14 March 2022

SSD7348 MOD 10, OAKDALE WEST STAGE – S.4.55(1A) APPLICATION TO MODIFY ARCHITECTURE PLANS

2.1.1 Estate Masterplan (OAK MP 02) update

2.1.3 Signage Precinct 1 Plan (OAK MP 12) Update

2.1.4 Lot 1A – Façade plan updates

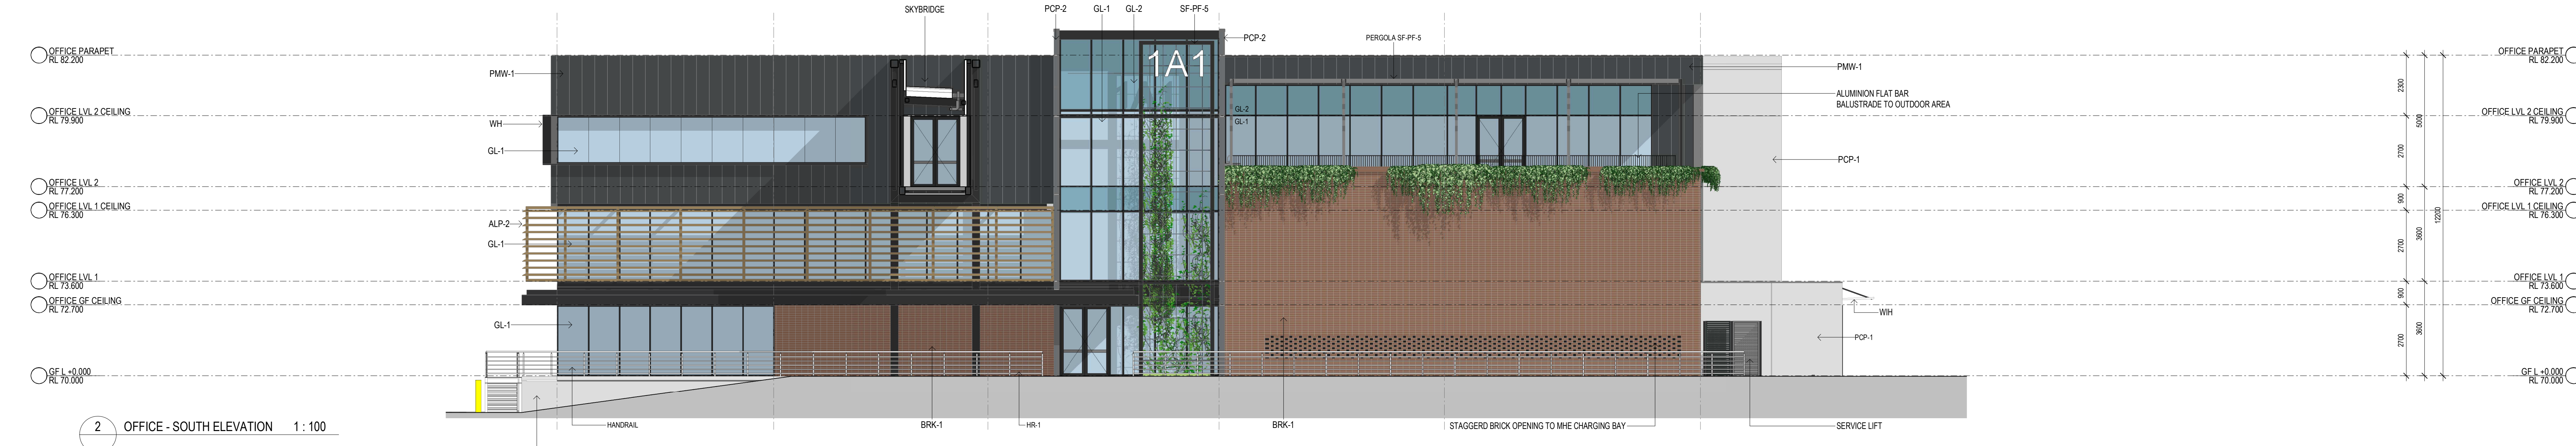
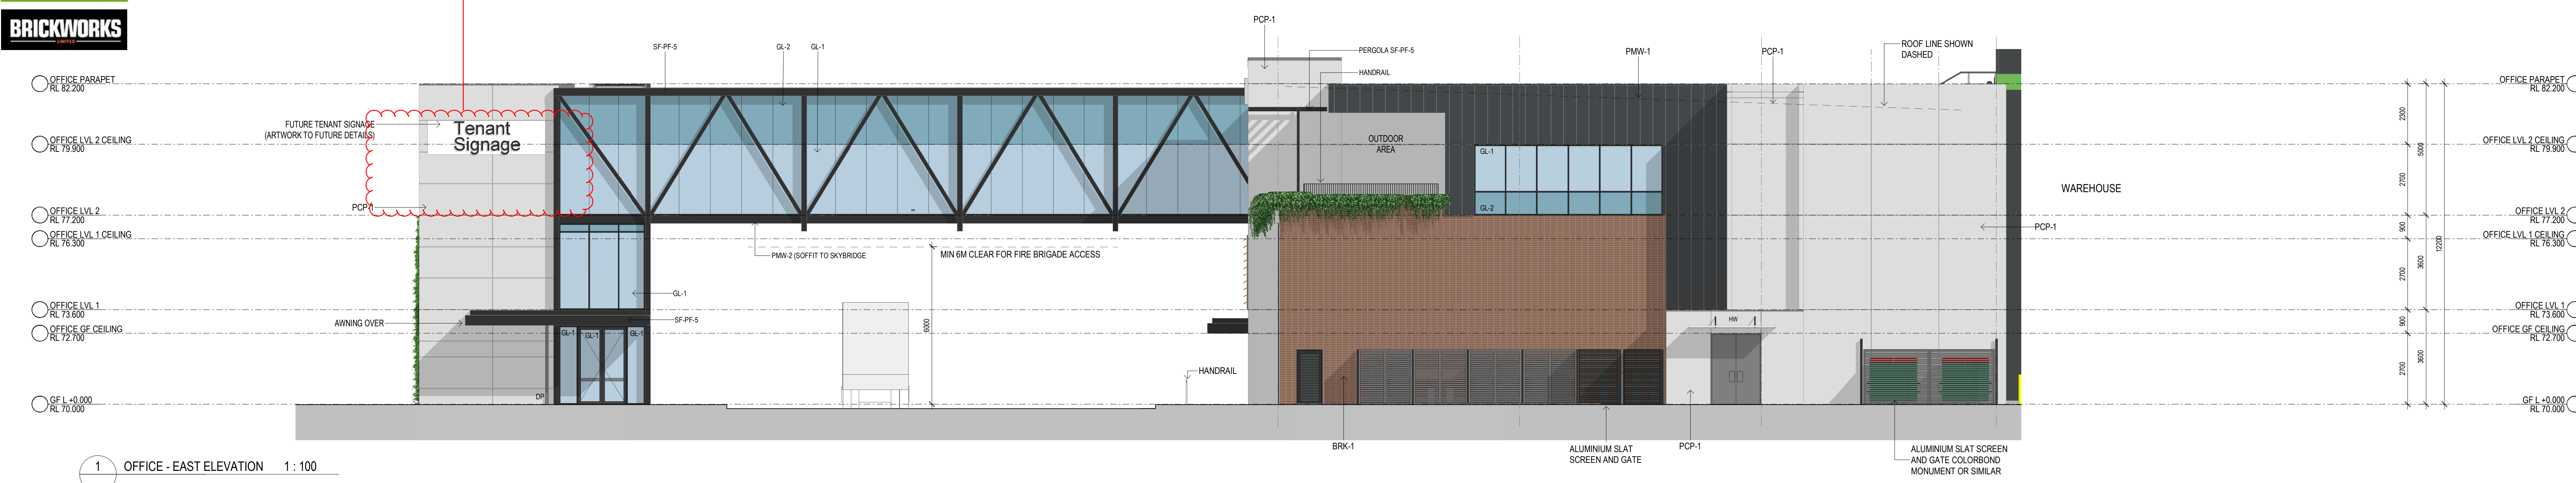
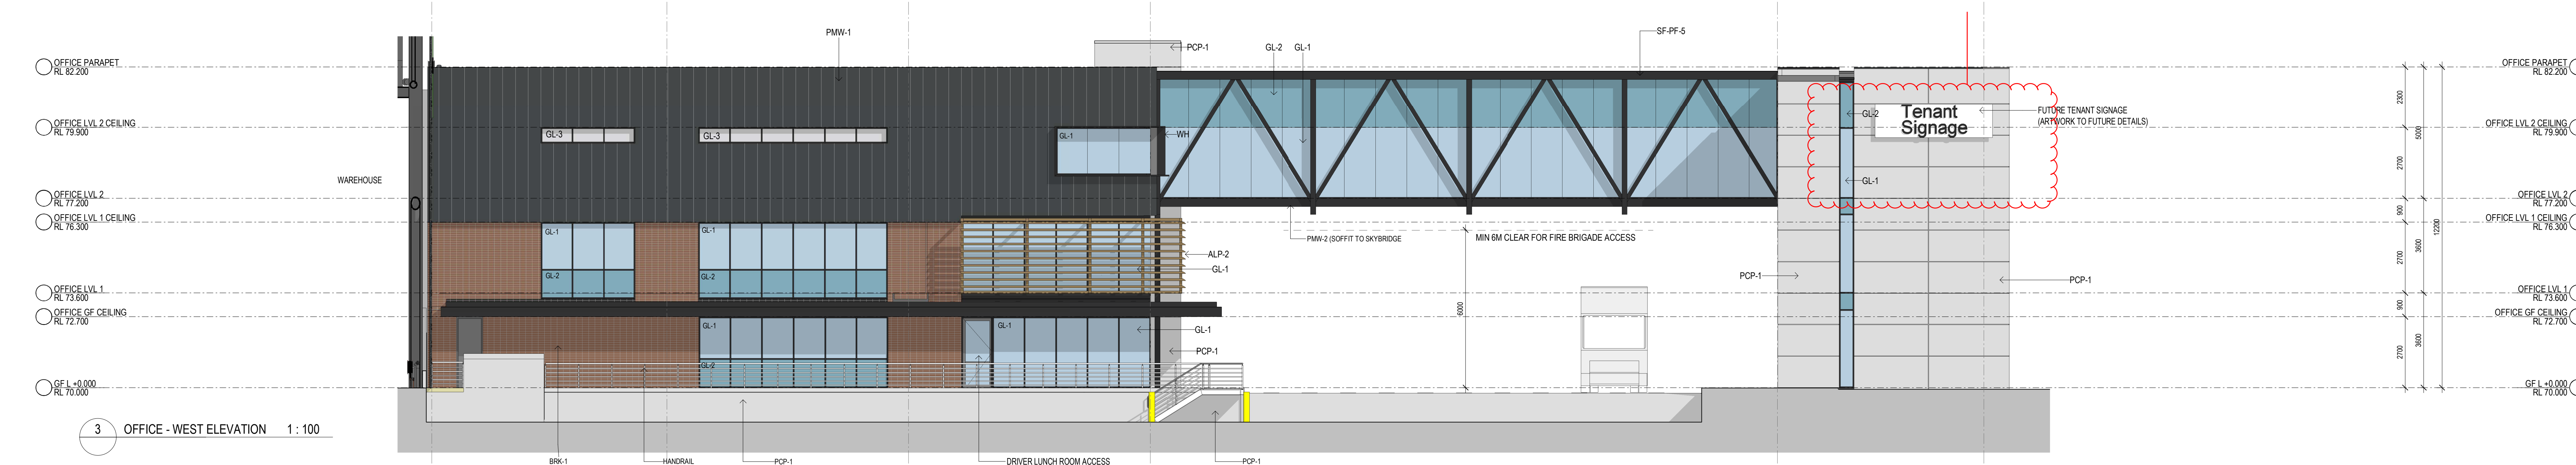
- 1) Pylon Sign (S1) sought for height increase from 16m to 16m height:
 - The proposed 16m height is considered more appropriately scaled considering the context, particularly the significant 36m adjacent Lot 1A warehouse.
 - The location of the S1 sign proposed to remain as approved.
 - The reason for the update is that the 16m sign would be too recessive considering the estate context.
- 2) Tenant façade signage “D” and “E” reduced in size as per customer request – refer **Fig.2**

- 3) Sign "E" removed from south east corner office of warehouse 1A

Façade plans for Warehouse 1A updated to show updated signage zones on the warehouse facade. The signage zones are primarily proposed to be reduced in size.
